ORIEL WIND FARM PROJECT

Environmental Impact Assessment Report – Addendum
Chapter 19 Addendum: Onshore Biodiversity

MDR1520C
EIAR – Chapter 19 Addendum
A1 C01
December 2025

Drawing file: Onshore cable drawings / B16 PE605-D027-018-001 RIVER DEE HDD CROSSING DRUMCAR BRIDGE.pdf

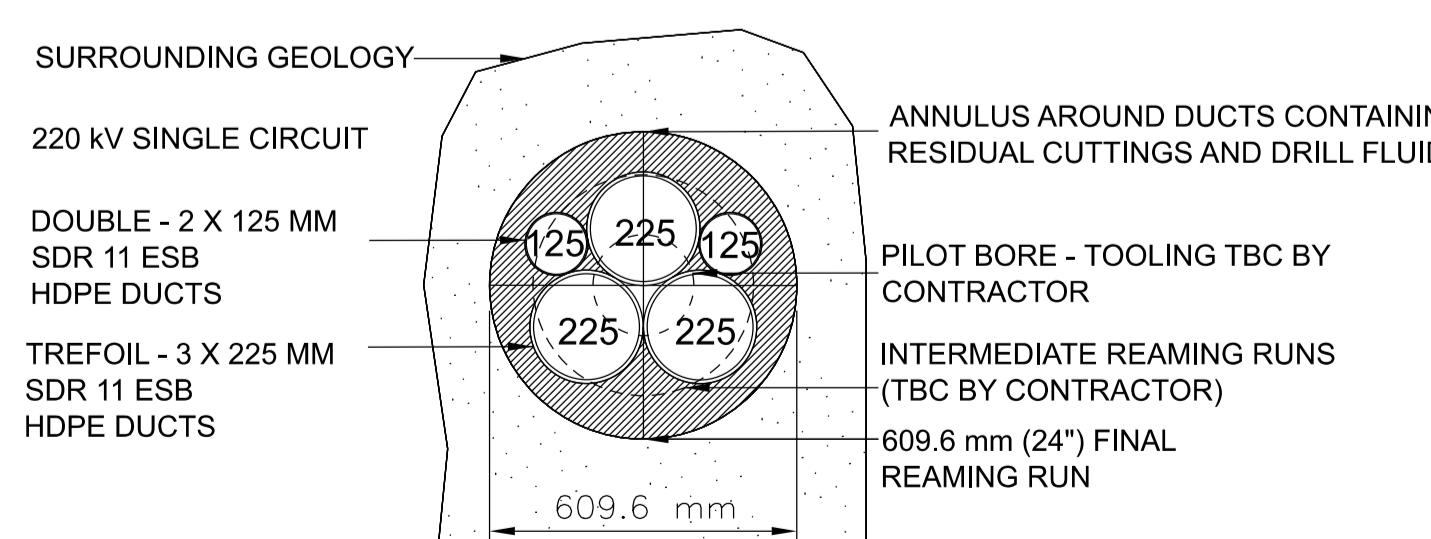
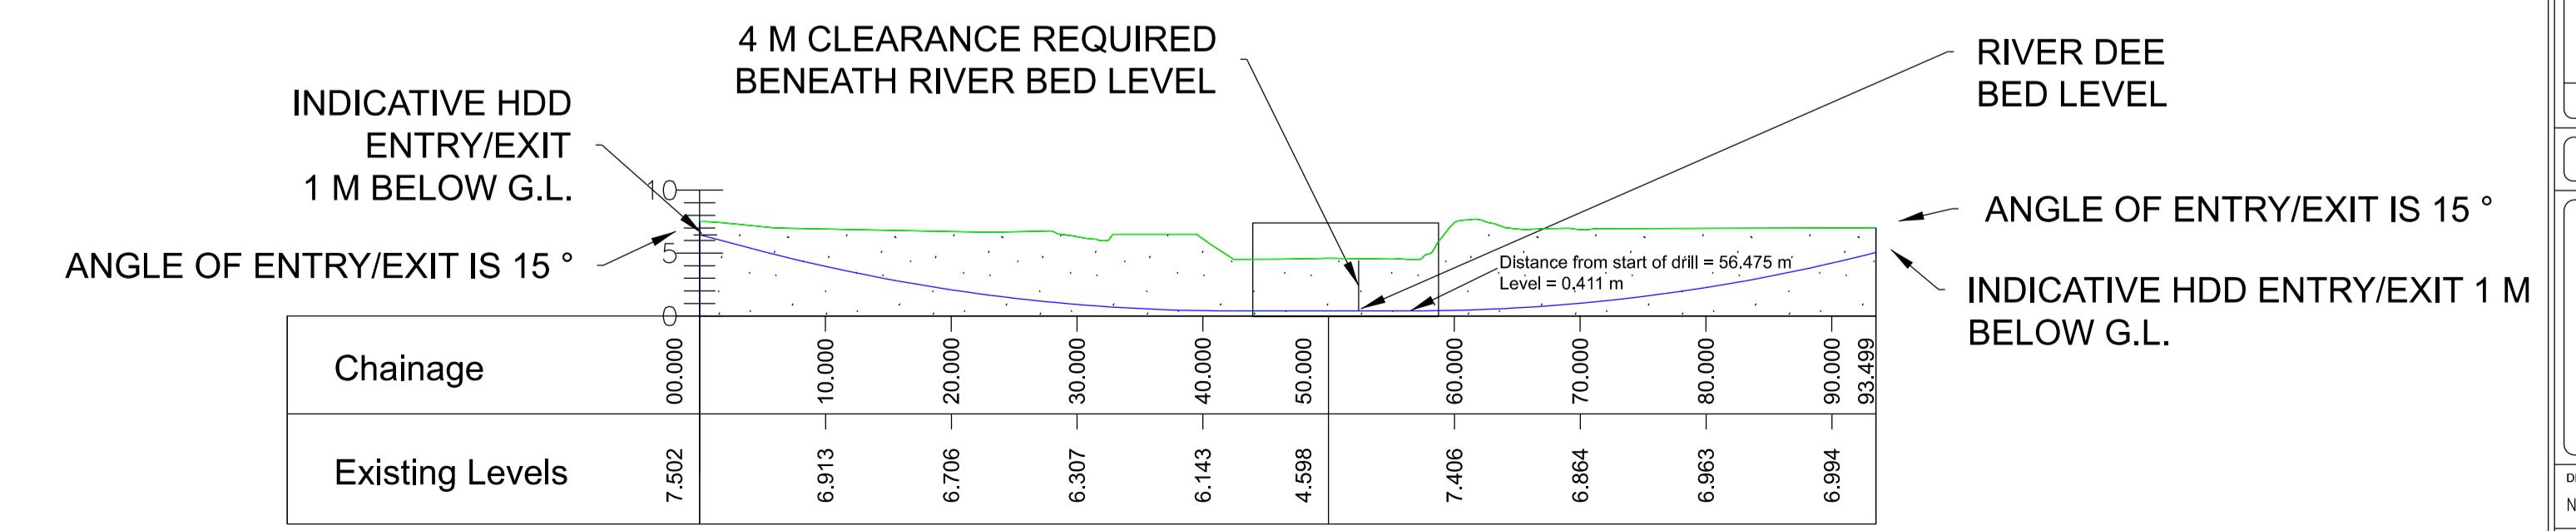
Reference	Request for Further Information	Response / Reference where information is presented	Concluding statement
14.E	<p>In terms of the impacts to terrestrial bats, the Board notes the high activity for bats at the eastern crossing of the River Dee. It is further noted that the development will include the felling of 7 mature trees – BT4, BT5, BT14-18 – all of which have been identified as having low suitability for roosting bats. The Board notes that trees BT14-18 are located within close proximity to the identified 'hotspot' at the eastern crossing of the River Dee. While potential direct effects have been identified to bats in the EIAR, and notwithstanding the disturbance measures included in Table 19-12 of Chapter 19: Onshore Biodiversity of the EIAR, the Board requests further justification in terms of the removal of the above 5 trees which are clustered proximate to this hotspot, together with the removal of the other trees identified, with regard to potential impacts to bats. The potential location for bat boxes, as indicated as an enhancement measure, should also be identified.</p>	<p>The following sections provide information in relation to removal of trees suitable for bat roosting and bat boxes:</p> <ul style="list-style-type: none"> Section 19.8.2; and Section 19.10.6. 	<p>No change to the assessment or conclusions presented in chapter 19: Onshore Biodiversity (EIAR volume 2C).</p>

At the eastern crossing of the River Dee (i.e. Drumcar), several trees were identified as having features suitable for roosting bats. Bat trees BT4, BT5 and BT14-18, were identified as having 'low' potential to support bat roosting. These trees are located approximately 100 m to the south east of the River Dee, as described in EIAR appendix 19-1: Onshore Biodiversity – Supporting Information (EIAR volume 2C).

To clarify, the identified 'hotspot' is associated with the River Dee corridor, not where the above trees are located. Additionally, these trees are of 'low' bat roosting potential and are proposed for 'soft' fell to protect any bats that happen to be roosting within them at the time of felling. Although they may support the wider commuting corridor available to local bat populations, their removal is not considered to effect bat activity or the 'hotspot' associated with the River Dee.

Drawing file: Onshore cable drawings / B24 PE605-D027-094-001 TRANSITION JOINT BAY OPTION 2 AERIAL.pdf

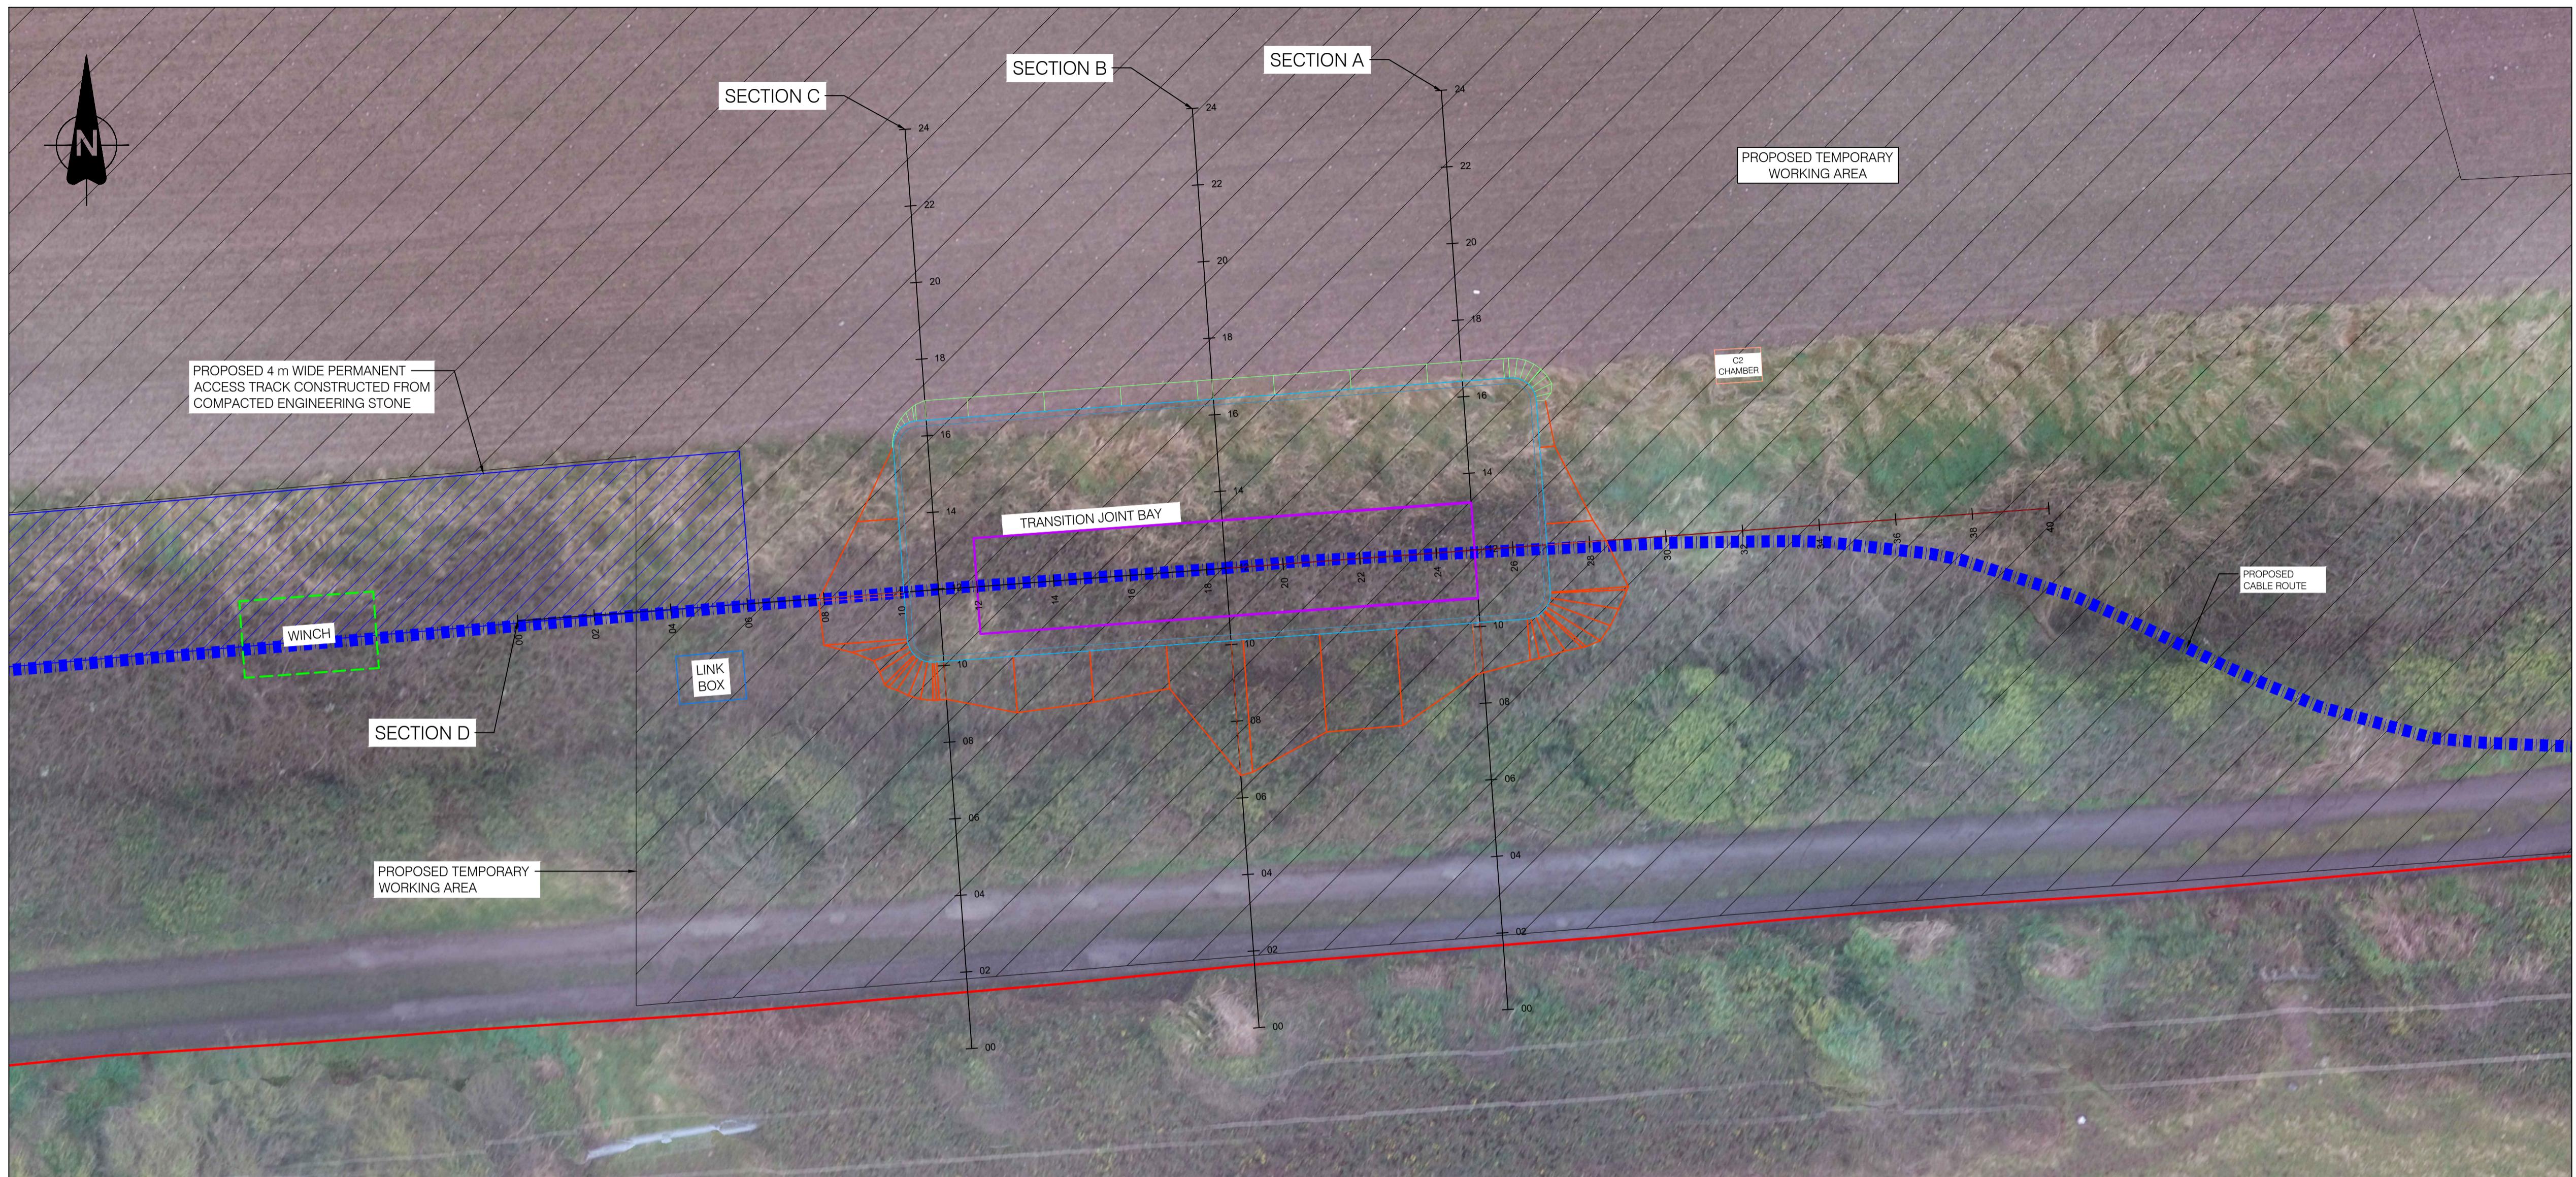
19.A	<p>The proposed landfall for the offshore cable is located within the Dunany Point pNHA (Site Code: 001856), and within a Sedimentary Sea cliff habitat as detailed in the EIAR (Appendix 19-01). The EIAR also identifies that the offshore cable corridor comes on shore 'at a shingle bank extending from the scrub (WS1) and dry calcareous and neutral grassland (GS1) habitats to below the High-Water Mark (HWM). Vegetation was restricted to the upper section of shingle and contained a single species of rare occurrence, curled dock <i>Rumex crispus</i>. Below the shingle bank a tidal mudflat and sandflat was present.' The Board notes that the occurrence of shingle beach adds to the scientific importance of Dunany Point pNHA, and that this habitat is as an Annex I habitat in the Habitats Directive.</p>	-	<p>-</p>

i)	<p>The DAU considers that the description of onshore habitats is limited in the EIAR, and that sections of the cliff habitat at and in the vicinity of the Dunany Point landfall might correspond to annexed habitat Vegetated sea</p>	<p>See section 19.6.3 which provides further information on the additional habitat surveys undertaken and section 19.7, which provides further information on the description of the habitat.</p>	<p>Following a review of the baseline characterisation for CS3 Sedimentary sea cliffs, this habitat meets the requirements (three positive indicator species) for the species composition associated with <i>vegetated sea cliffs of the Atlantic and Baltic</i></p>

However, the repositioning of the TJB (options 1 and 2) at the landfall location, as detailed in section 5.5.9 of chapter 5 Addendum: Project Description (EIAR volume 2A Addendum), will avoid CS3 Sedimentary sea cliffs, therefore eliminating the potential for any impacts on this habitat.
